Current Zoning: N1-A (neighborhood 1-A)
 Proposed Zoning: N2-A(CD) (neighborhood 2-A, conditional)

Approximately 12.11 acres located on the south side of Sunset Road, east of Oakdale Road.

The petition proposes the development of up to 110 multi-family attached dwellings and 4 duplex lots. The property is currently the site of 2 single-family dwellings.

**RZ-1**

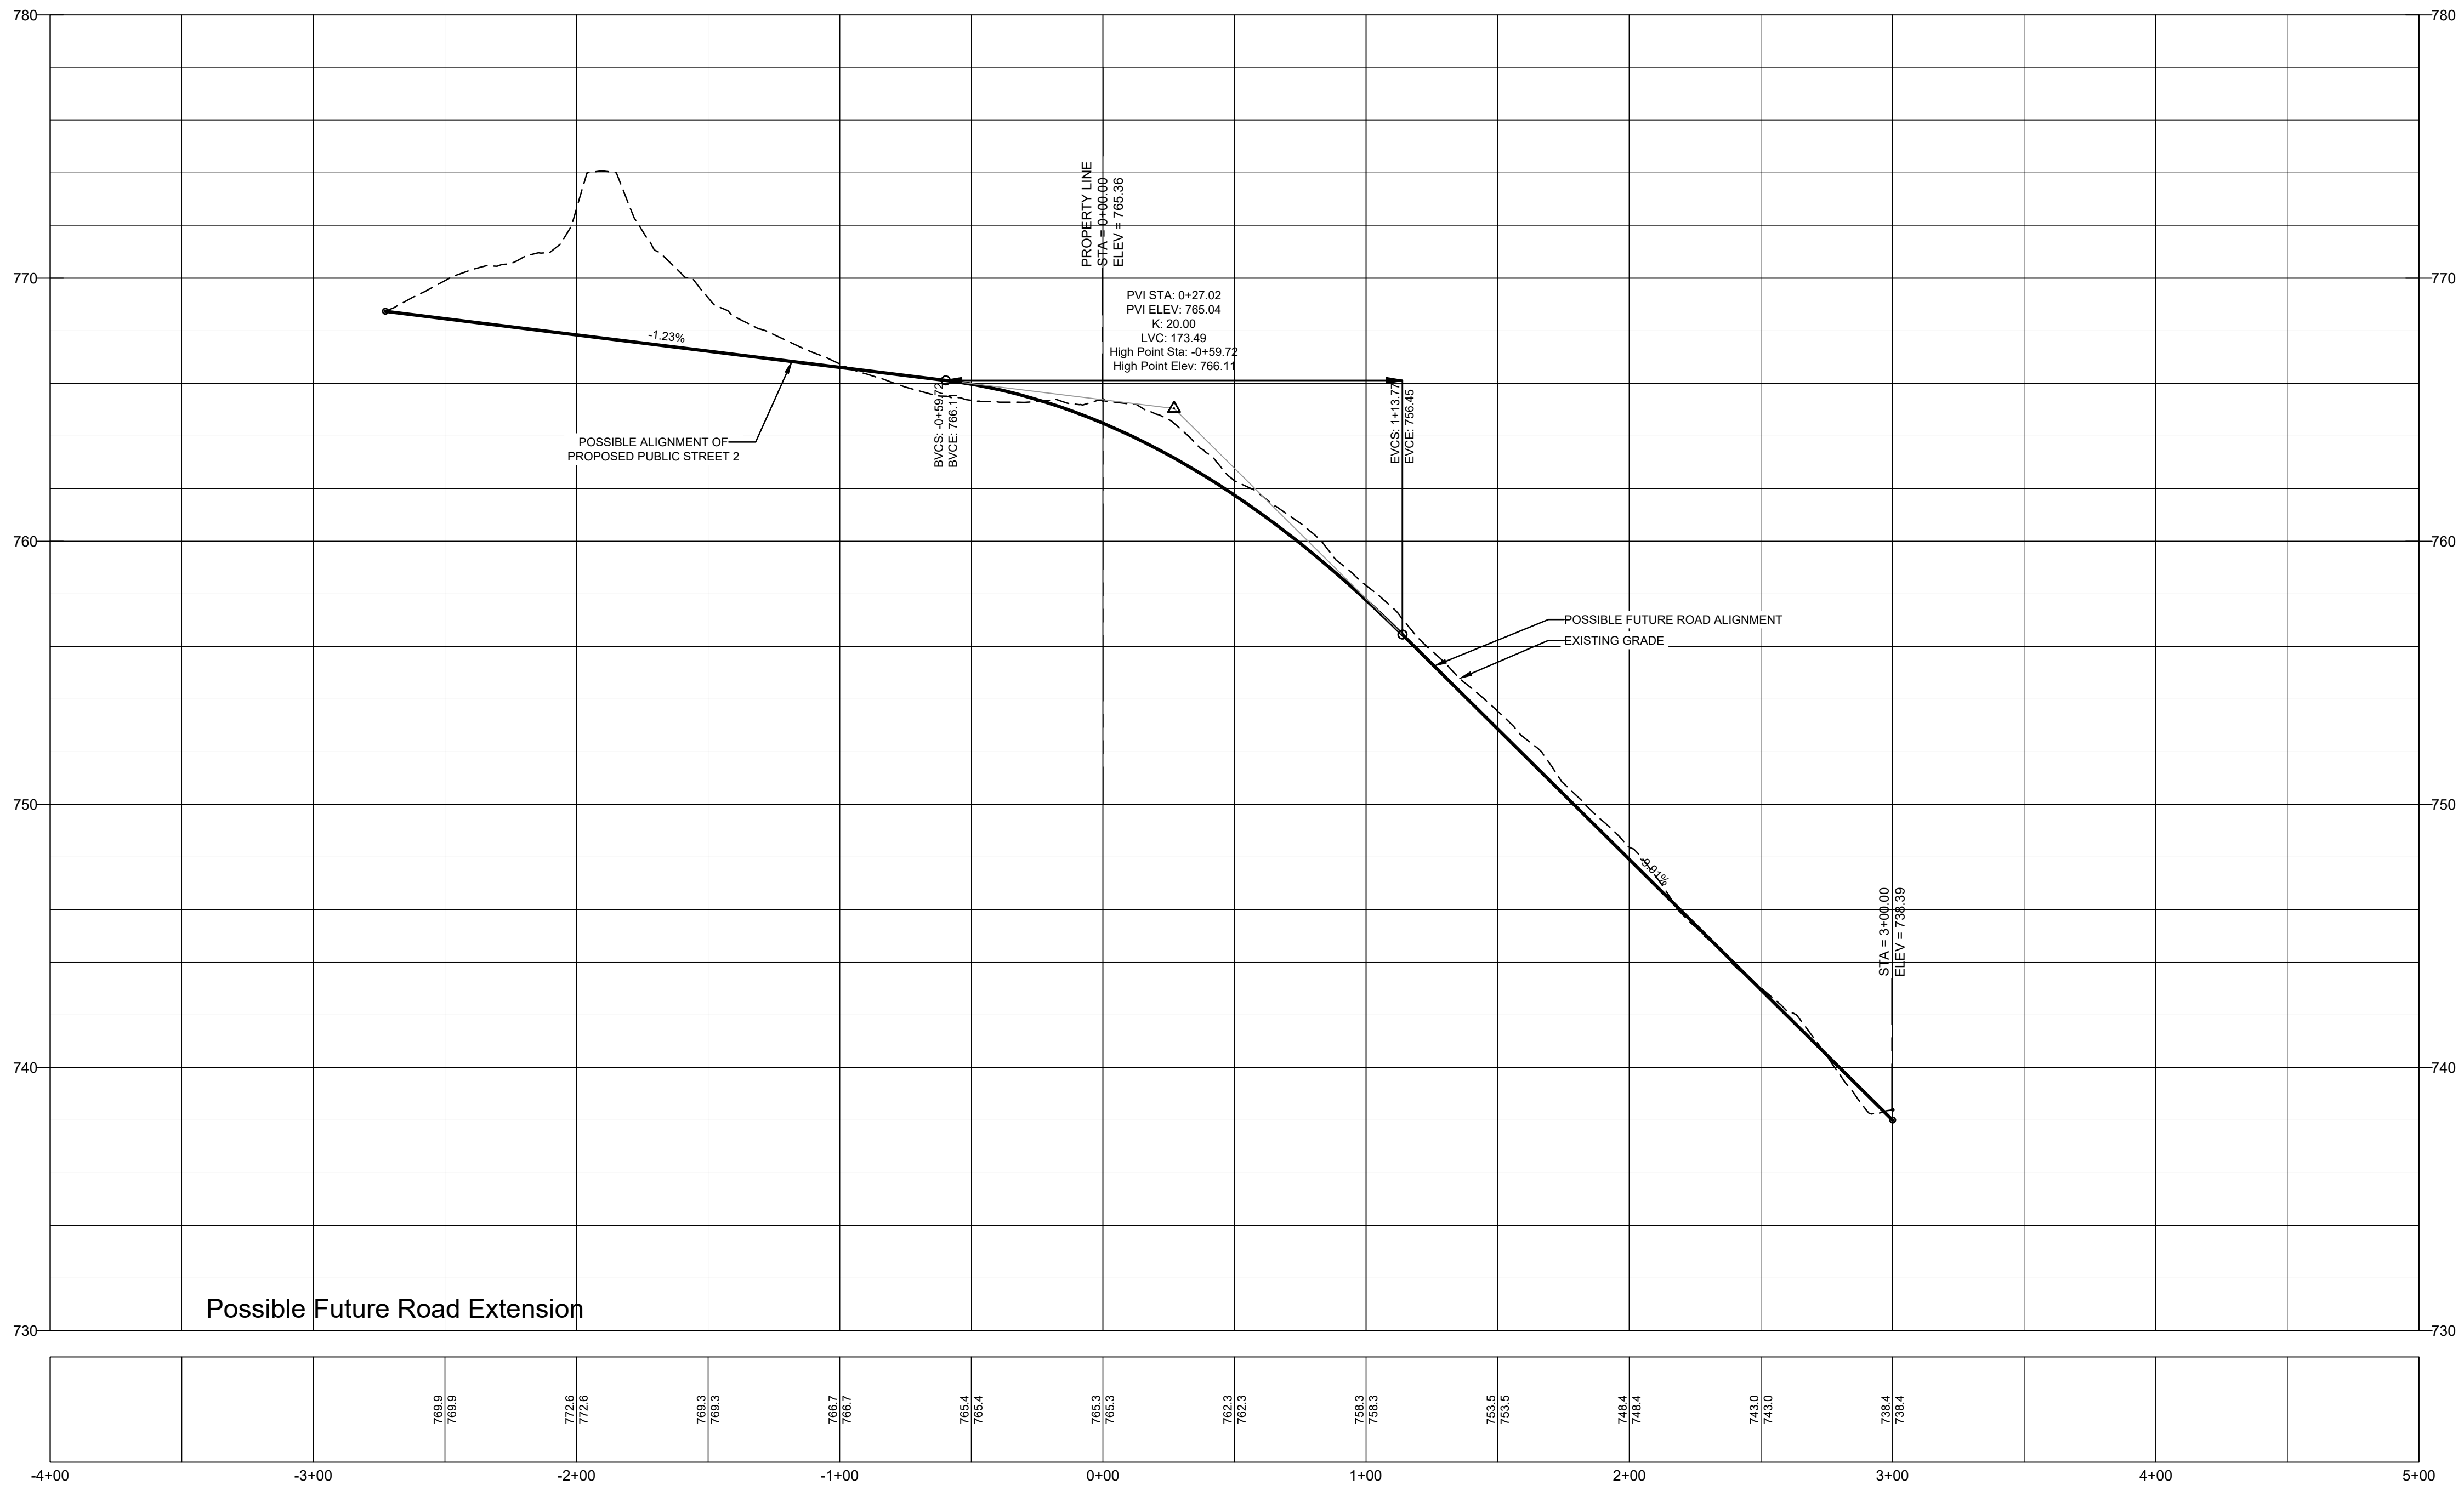
1. ~~Revise site plan and conditional note(s) to commit to creating cross access with the western (plan north) Parcel fronting Sunset Road per Article 31.2 in the UDO (See CDOT memo for diagram).~~

3. Stormwater: Add note regarding mitigation of impaired/degraded stream.
4. Stormwater: Add note regarding analysis of adequacy of the existing storm water conveyance to the nearest public right-of-way.
